CITY OF PORTLAND

May 14, 2004

RE: Application for Minor Site Plan, 498 St. John Street
(CBL#079C001) (ID#2004-0029)

79-C-1

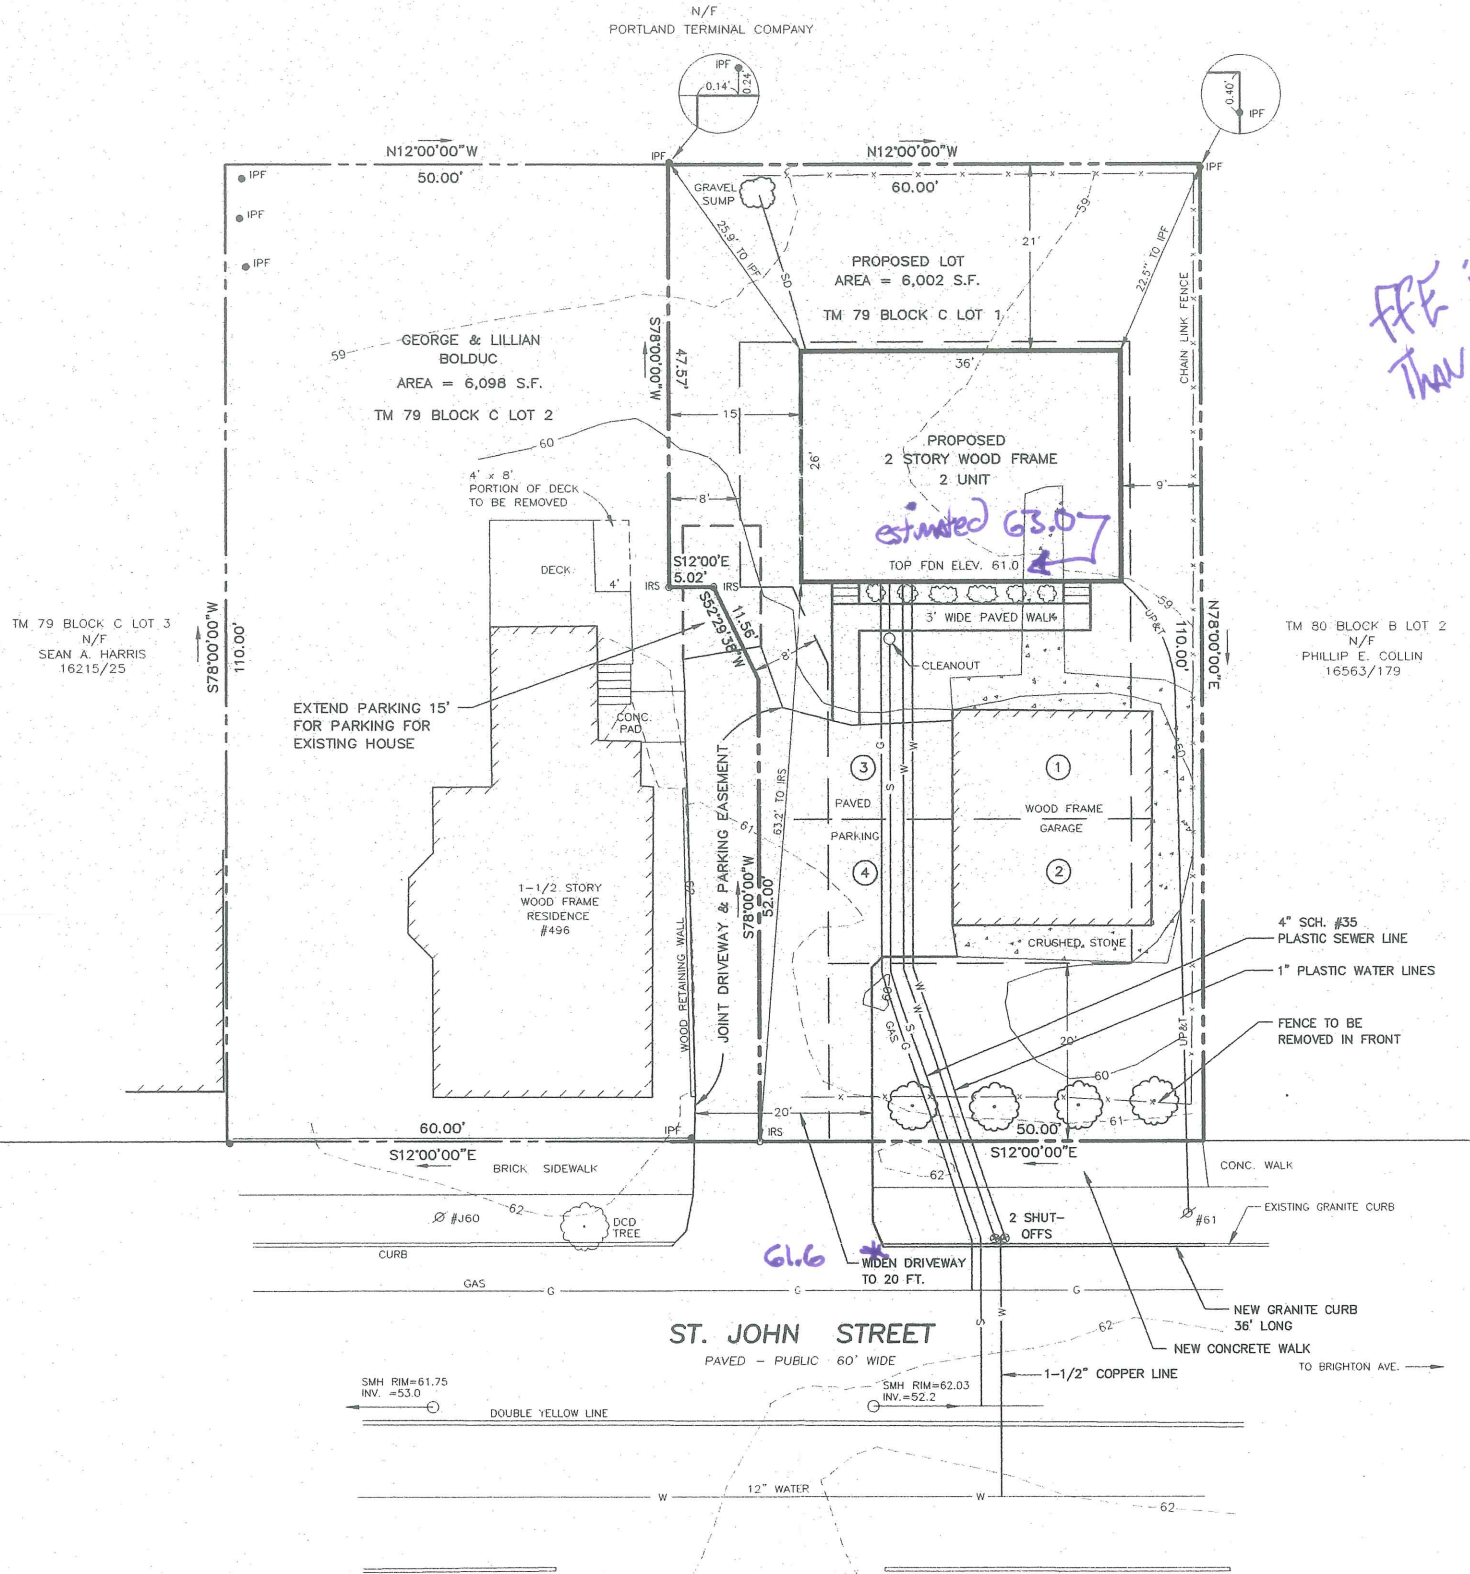
1. *Granite curb and bituminous sidewalk is required to be installed along the frontage of the property, per City of Portland specifications. Revised plans shall be submitted showing the location of the required curb and sidewalk.*
